From: Laura Gibbons
Sent: 20 May 2019 12:29
To: Planning.Responses
Cc: Andrew Wood
Subject: RE: Planning Consultation on: A/45/19/PL

Engineers Comments Regarding Surface Water Drainage

APPLICATION **A/45/19/PL**

Description of Works: Demolition of existing buildings (car show room, workshops and Phares Courtledge) and erection of 19 dwellings, a convenience store, a community building, public toilets and associated car parking and landscaping - This application affects the character and appearance of the Angmering Conservation Area.

-SURFACE WATER STRATEGY-

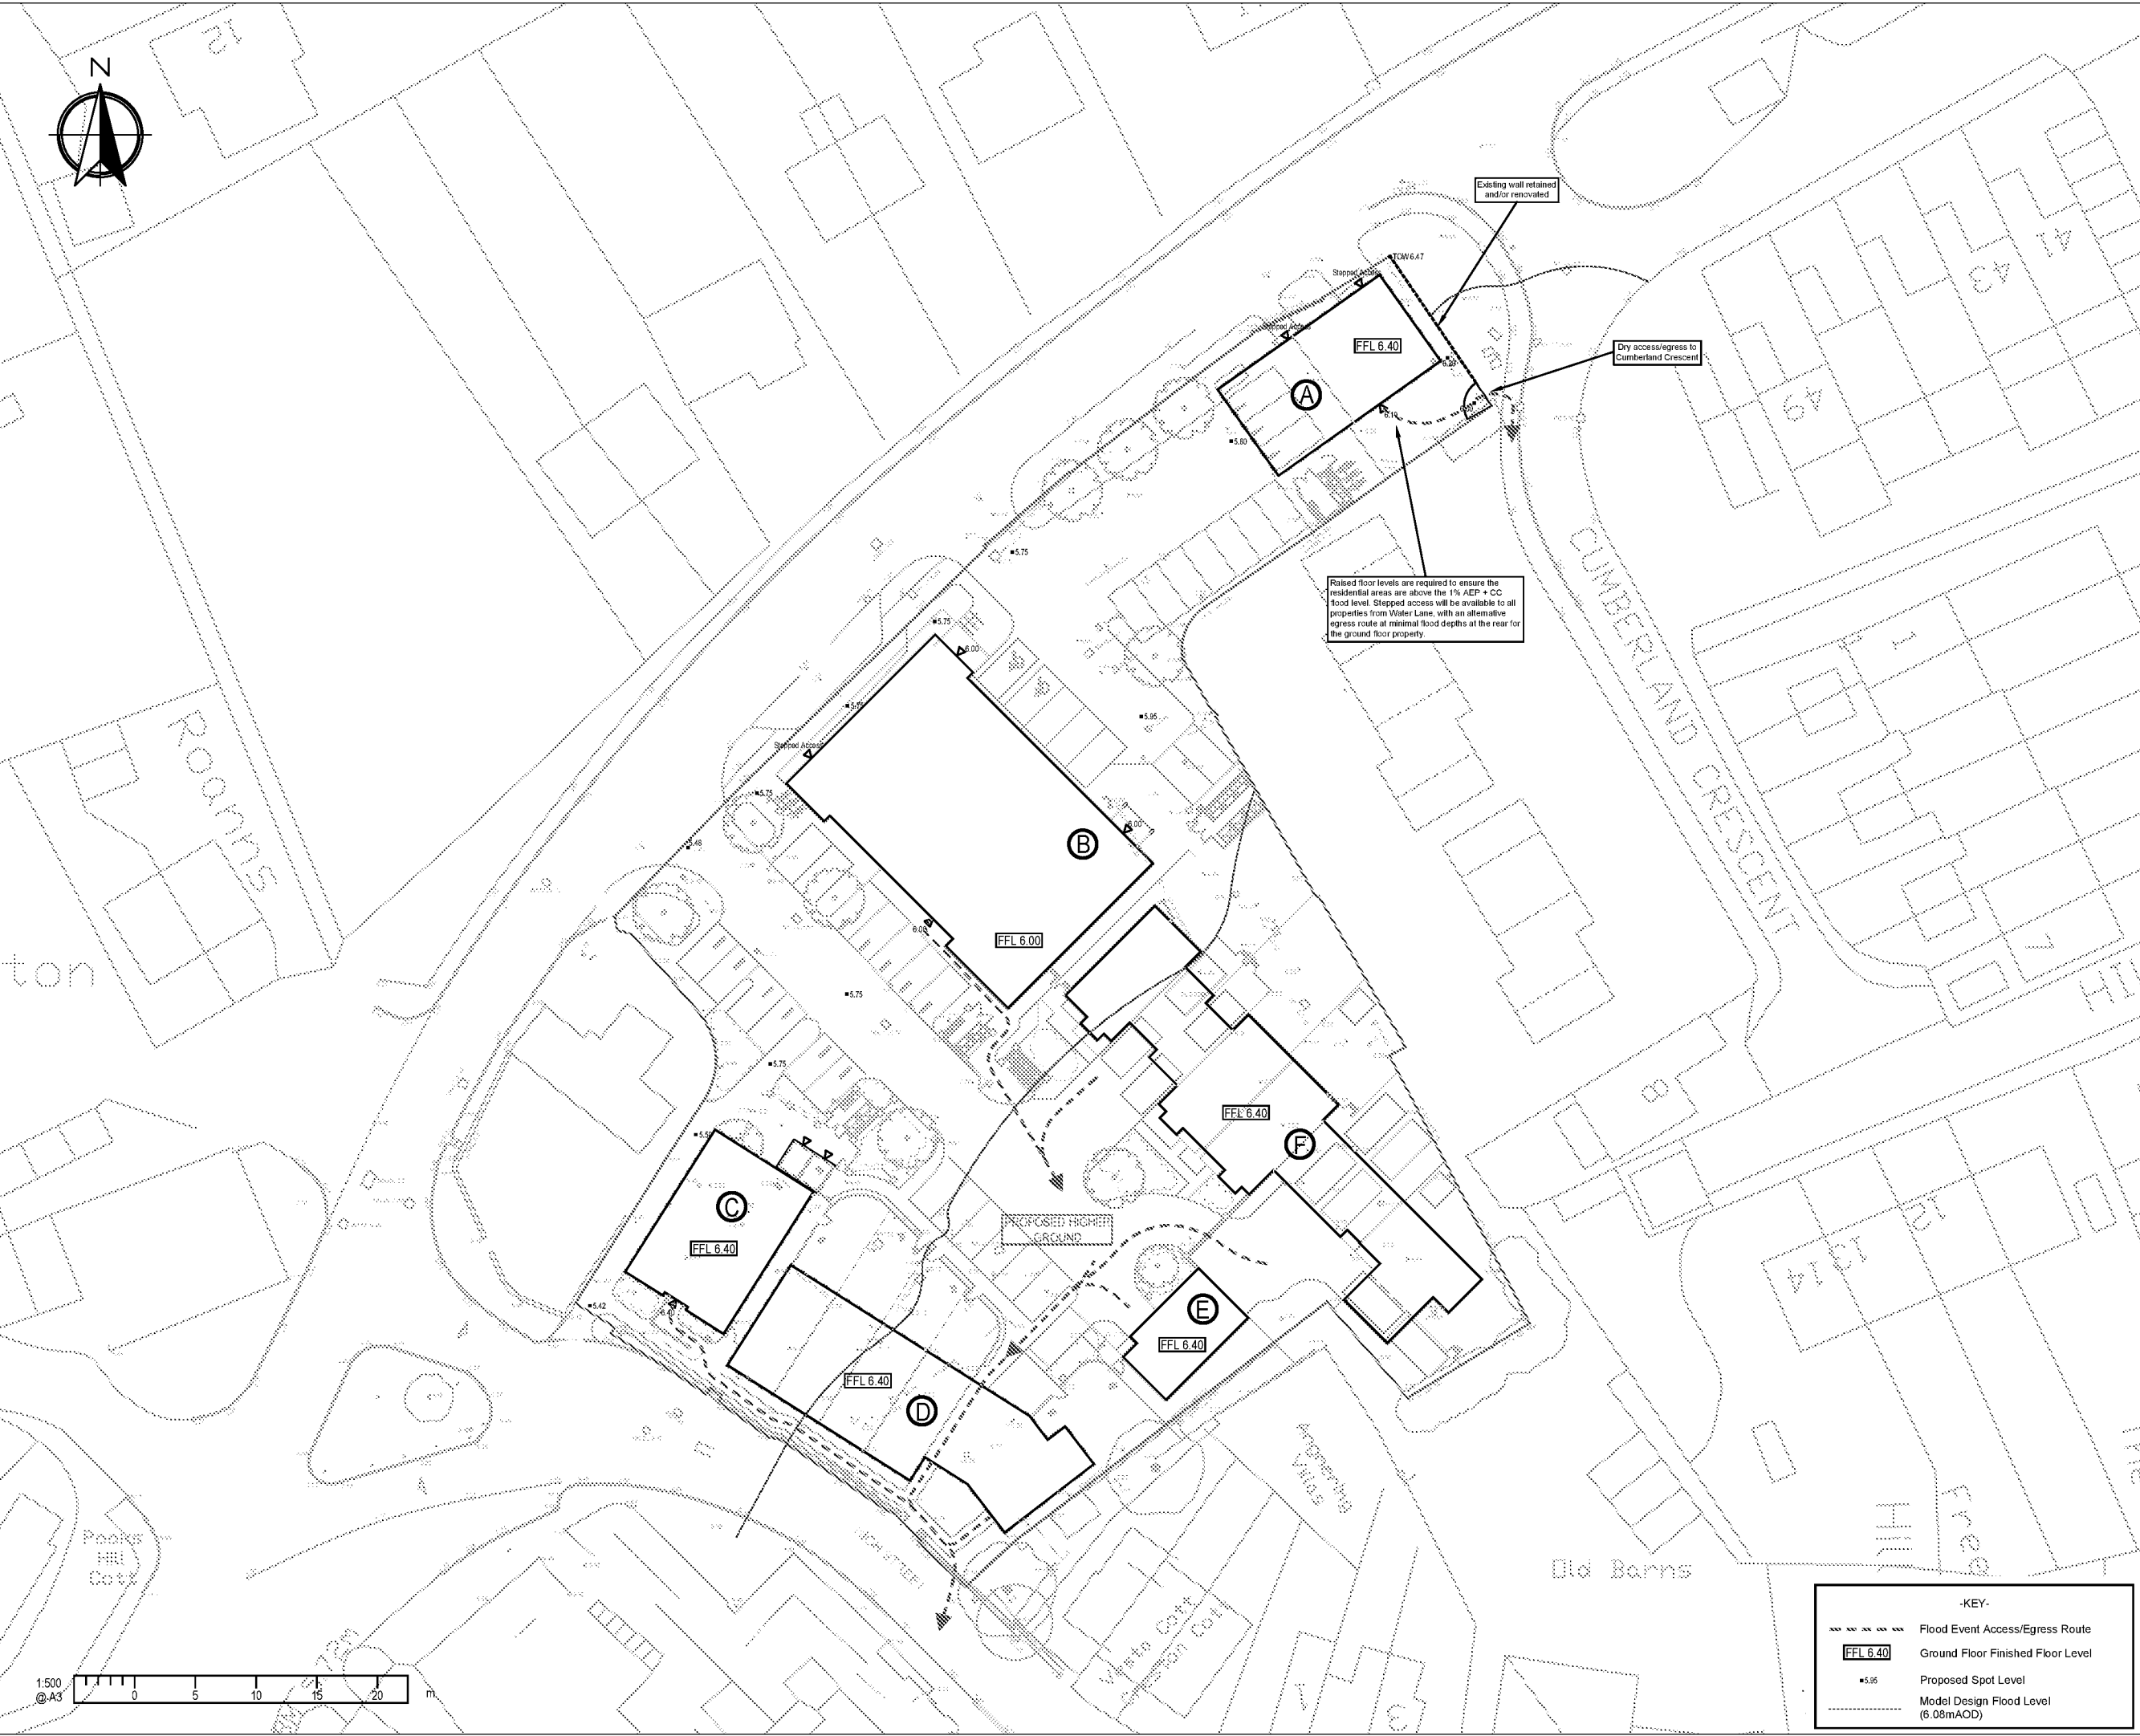
The submitted FRA details that some of the existing drainage arrangement will be utilised. Given the high risk of flooding in the area we would be looking to obtain improvement from the proposals, in line with WSCC policy we require proposed discharge rates to be as close to greenfield QBar as possible. Any proposals to alter or provide additional connections to the culverted main river would require a flood risk activity permit from the Environment Agency.

It is not clear from the detail submitted if the attenuated volume can be contained on site outside of the predicted flood extents. I.e. it has not been demonstrated that the proposals will not increase flood risk and the development can be adequately drained. A layout plan of the proposed surface water drainage scheme needs to be submitted, with further refined calculations. This information needs to be submitted before determination of the application. **Therefore, I currently object to the proposal.** Once further detail has been supplied by the applicant please re-consult.

"Development shall not commence, other than works of site survey and investigation, until full details of the proposed surface water drainage scheme have been submitted to and approved in writing by the Local Planning Authority. The design should follow the hierarchy of preference for different types of surface water drainage disposal systems as set out in Approved Document H of the Building Regulations, and the recommendations of the SuDS Manual produced by CIRIA. Winter groundwater monitoring to establish highest annual ground water levels and winter Percolation testing to BRE 365, or similar approved, will be required to support the design of any Infiltration drainage. No building / No part of the extended building shall be occupied until the complete surface water drainage system serving the property has been implemented in accordance with the agreed details and the details so agreed shall be maintained in good working order in perpetuity."
